Application for Planning Permission

Development: Erection of single storey rear extension following the demolition of existing lean to.
Location: 5 Davenport Road Felpham PO22 7JP

DATE	REVISION	BY
5 Davenport Road Felpham Bognor Regis West Sussex PO22 7JP		
DRAWN RD	CHECKED	
SCALE 1:50	DATE 01.01.22	
PROJECT TITLE Proposed Extension to 5 Davenport Road		
DRAWING TITLE Existing Ground Floor Plan		
DWG NUMBER 001		REV
NEG NUMBER

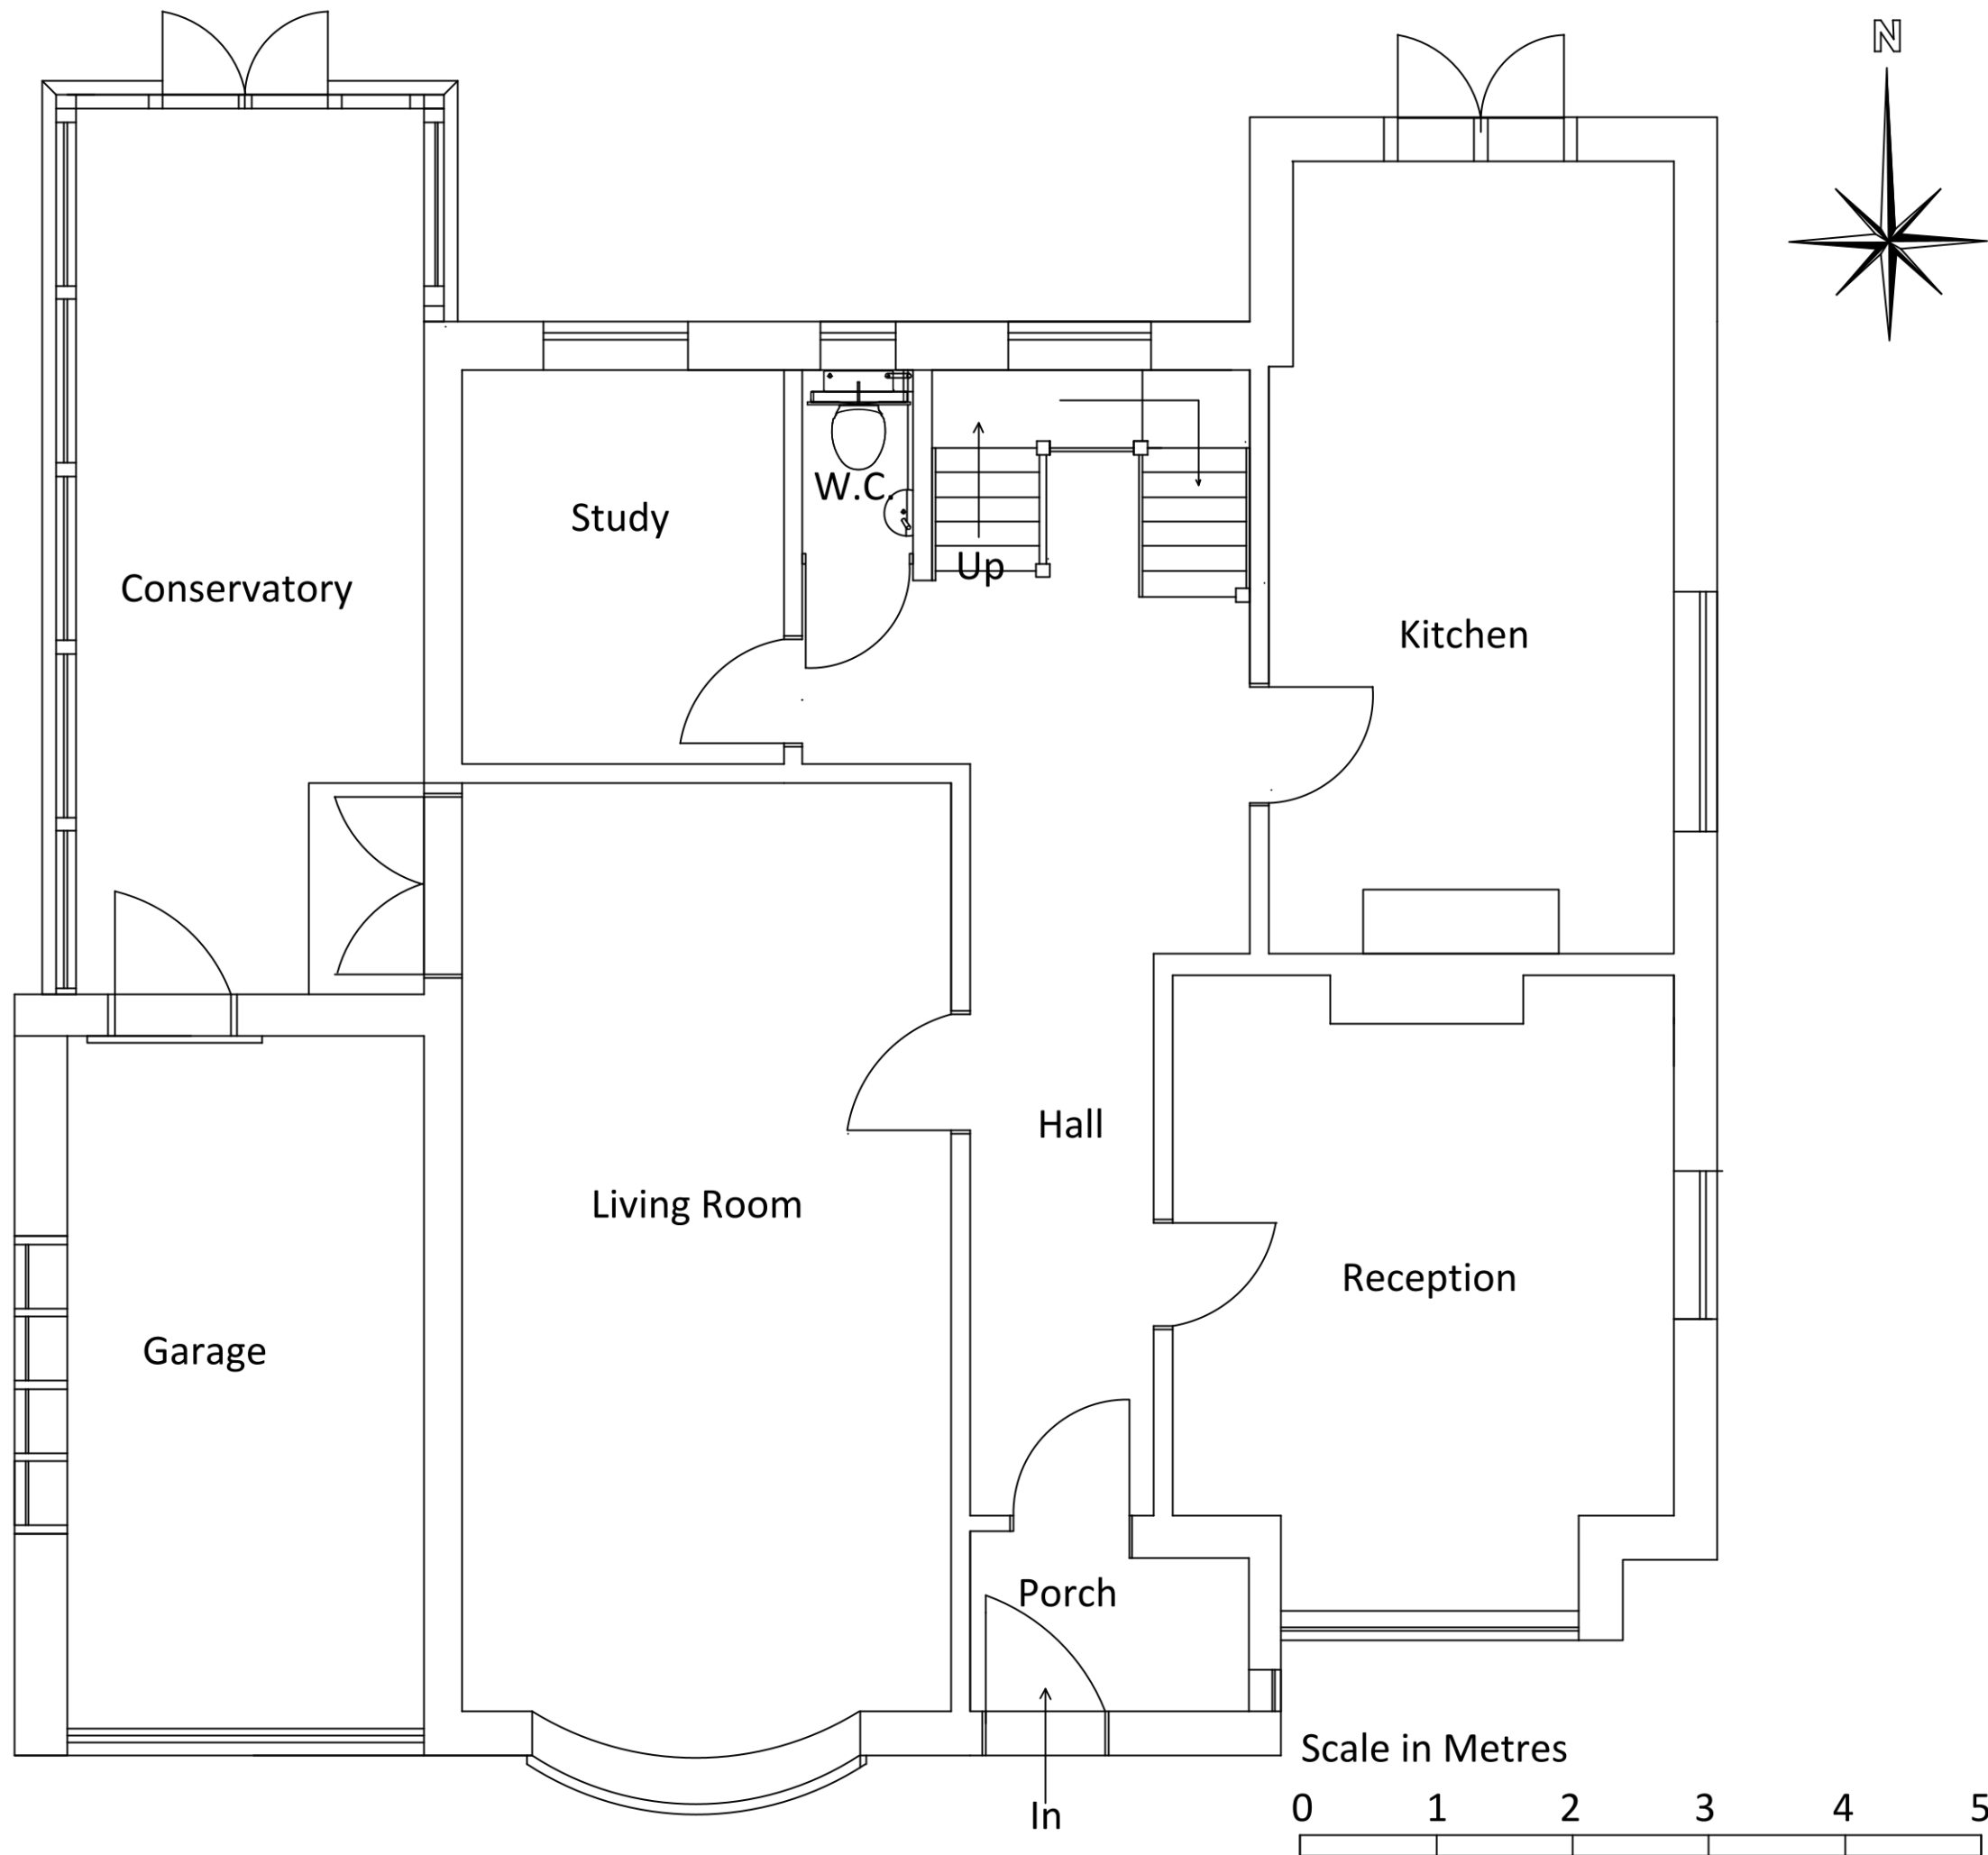
Please submit clearly labelled existing floor plans and elevations at a scale of 1:50 or 1:100. Further details can be found in the Validation Requirements List.

LOCATION PLAN

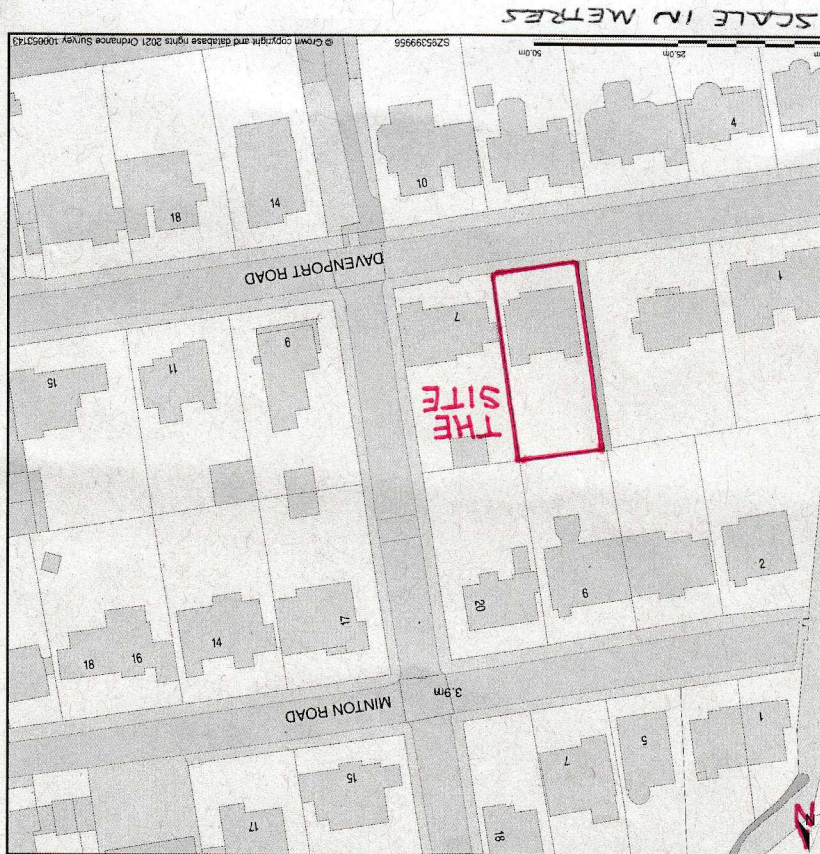
The location plan requires a solid red outline around the site boundary. Further details of what must be included on the plan can be found in the Validation Requirements List.

Proposed East Elevation

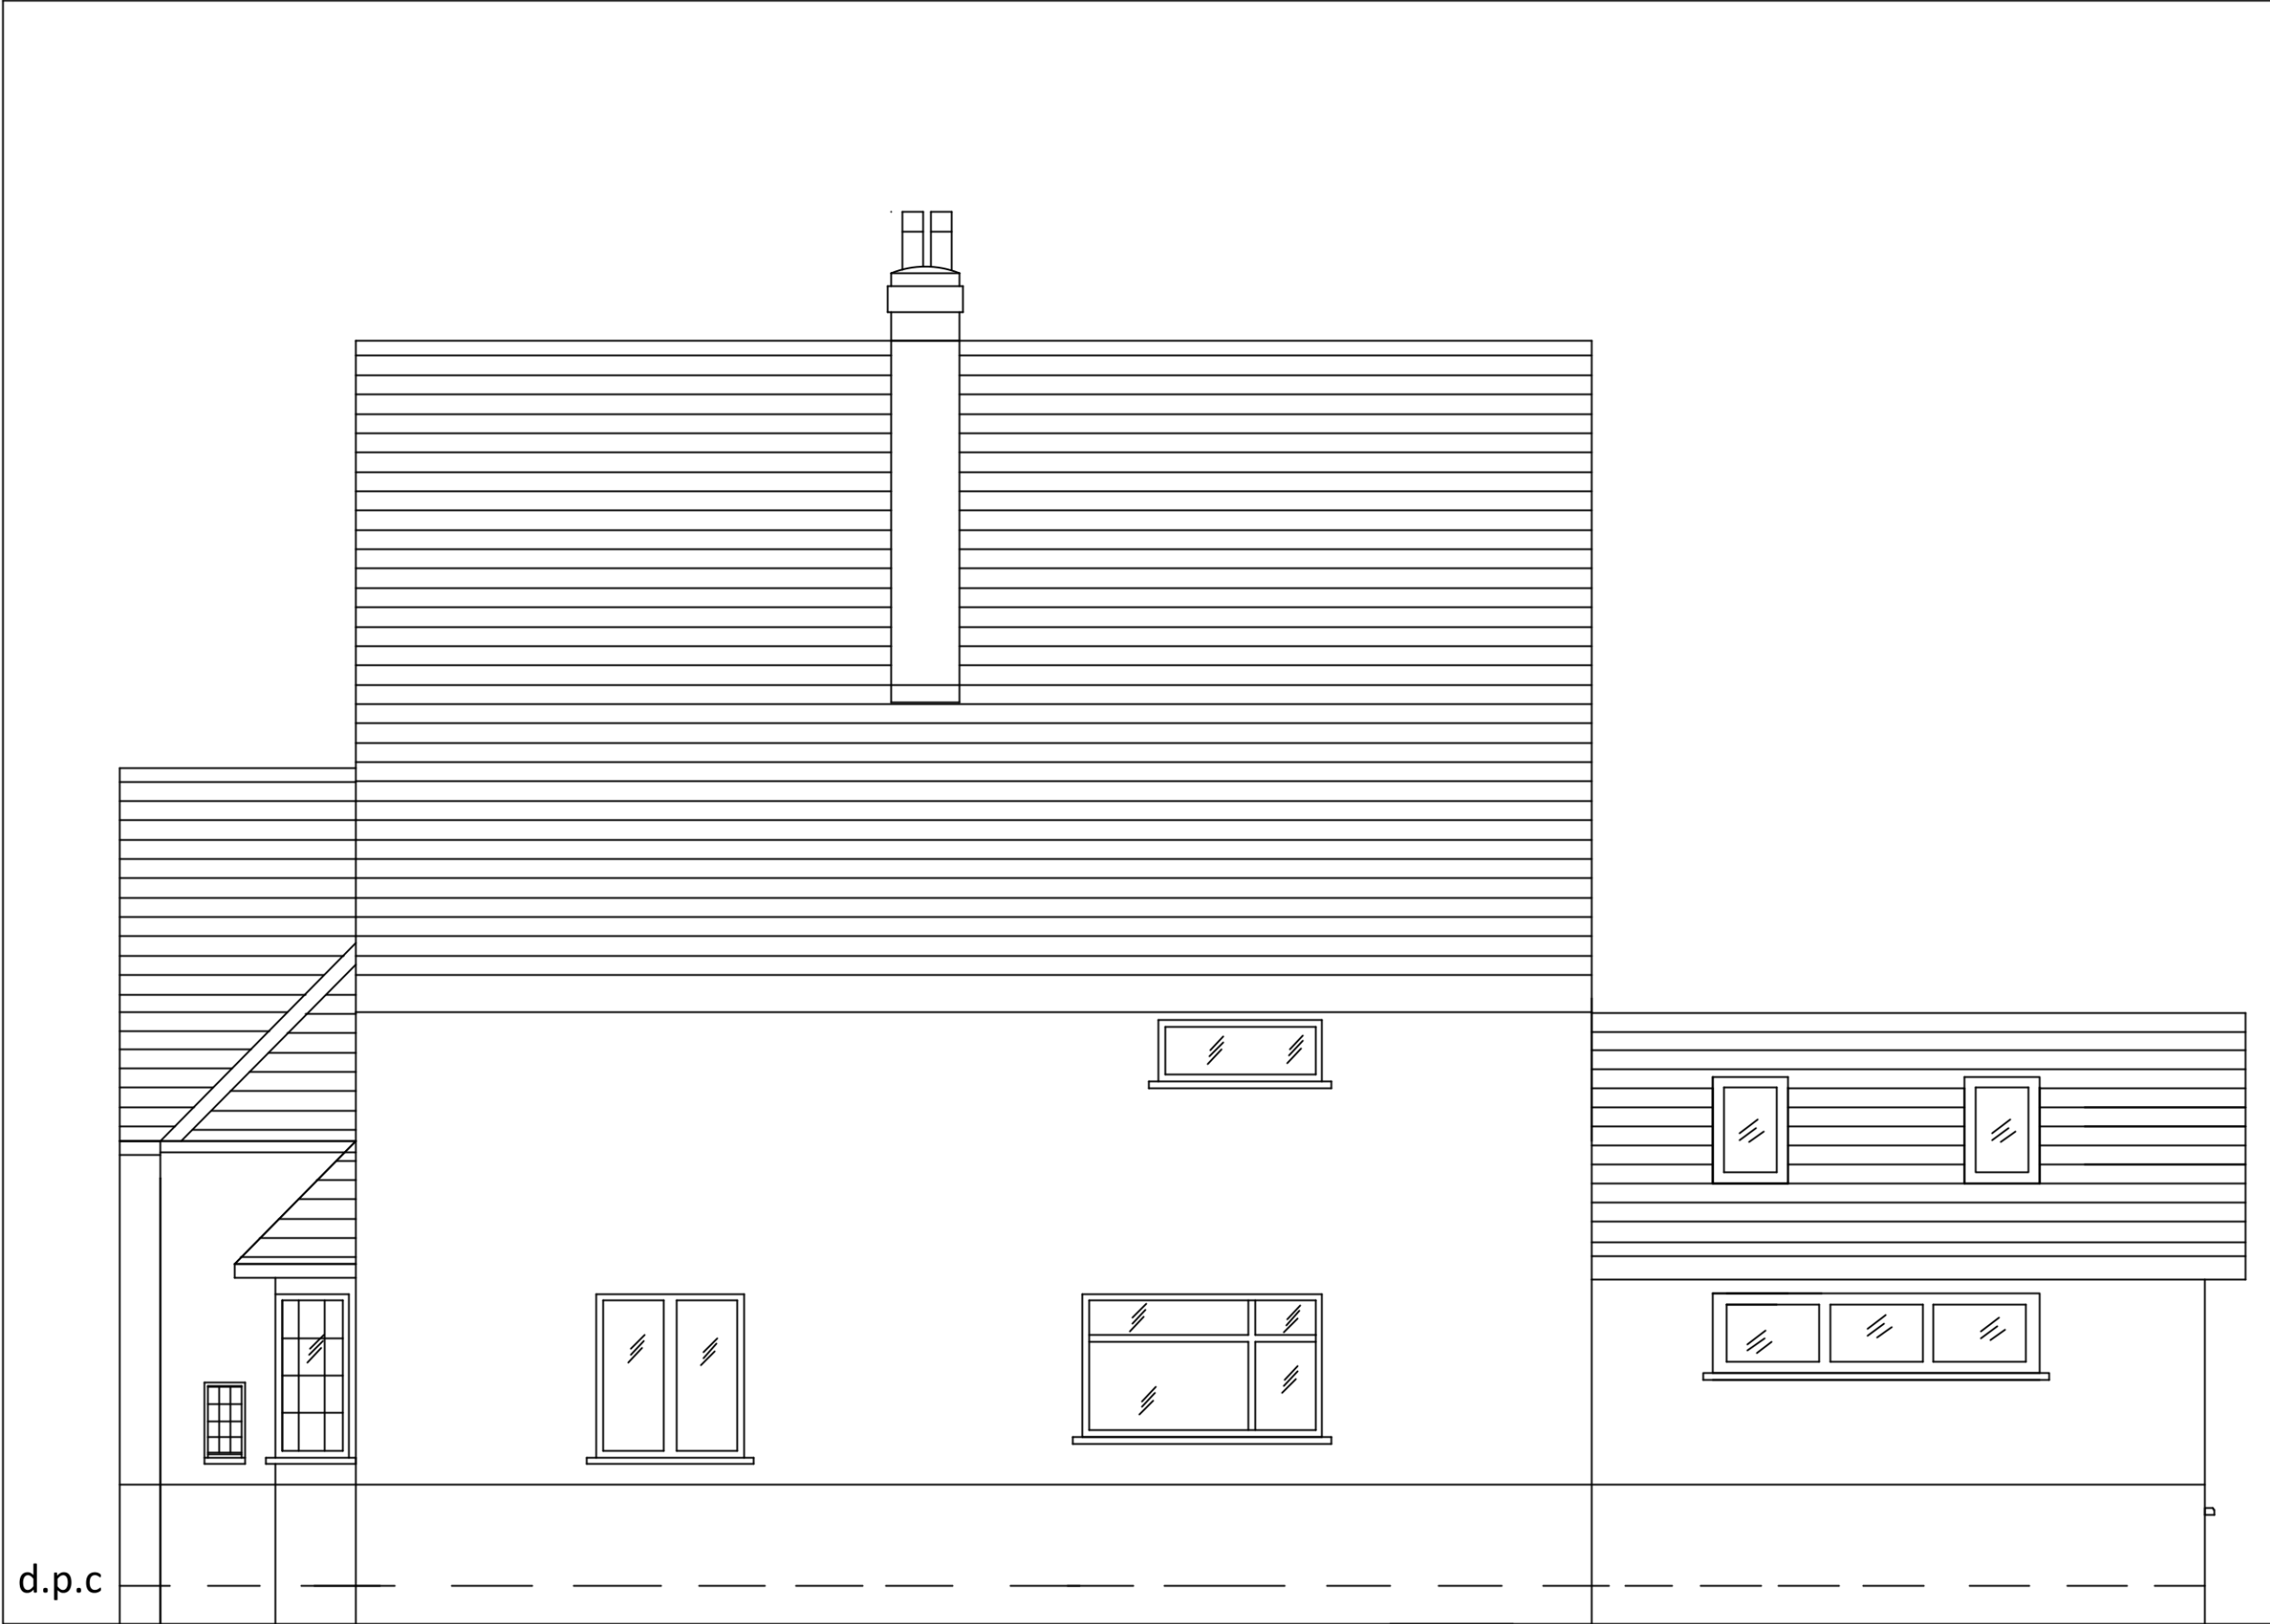
Please submit proposed elevations at a scale of 1:50 or 1:100. Along with this, the proposed floor plans require a stated scale. Further details can be found in the Validation Requirements List.
